Your Ref: OWQC766
Our Ref: BR/106/13/
Please ask for:
Simon Davis

12th August 2013

Removal of double garage and replace with detached 3 bed dwelling
1 Arnhem Road Bognor Regis

1 Arnhem Road		Proposed Dwelling	
	06	Edition 0	Sheet

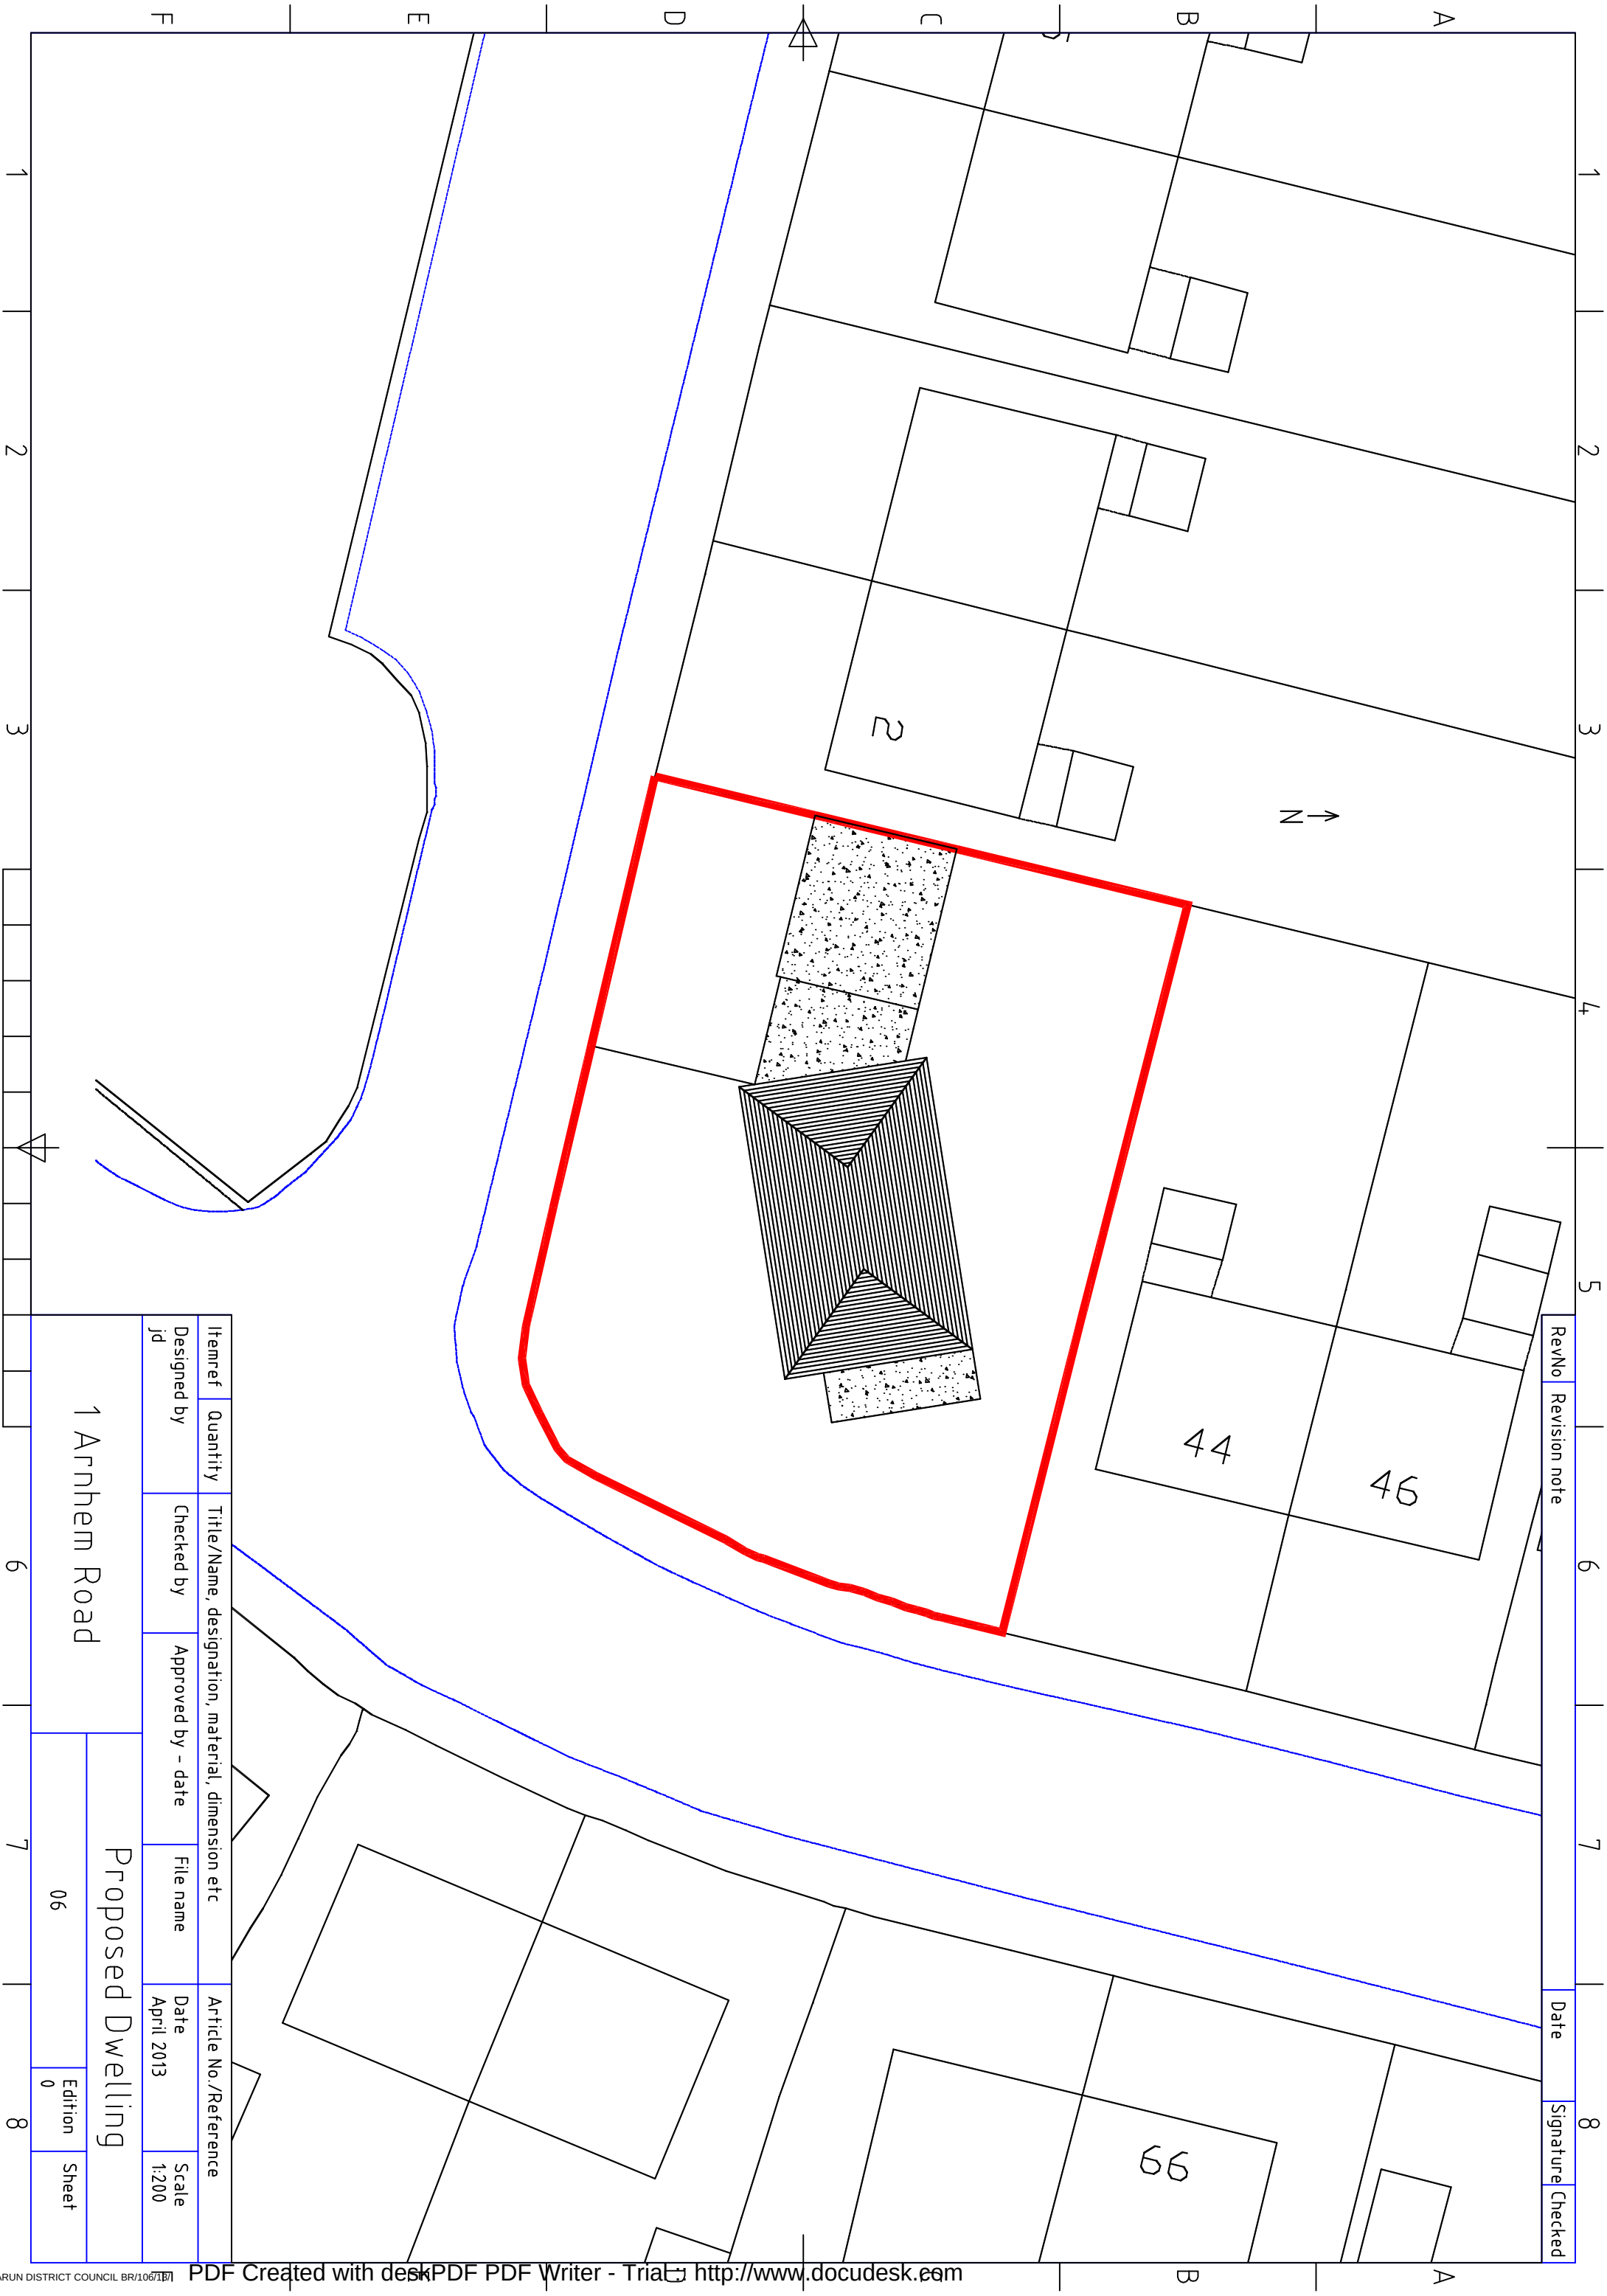
NO OBJECTION but concerns were raised over the distance allowed between the two houses, fearing the new dwelling would not leave sufficient space. Members also commented that the drawings do not seem to correspond with the overall footprint.
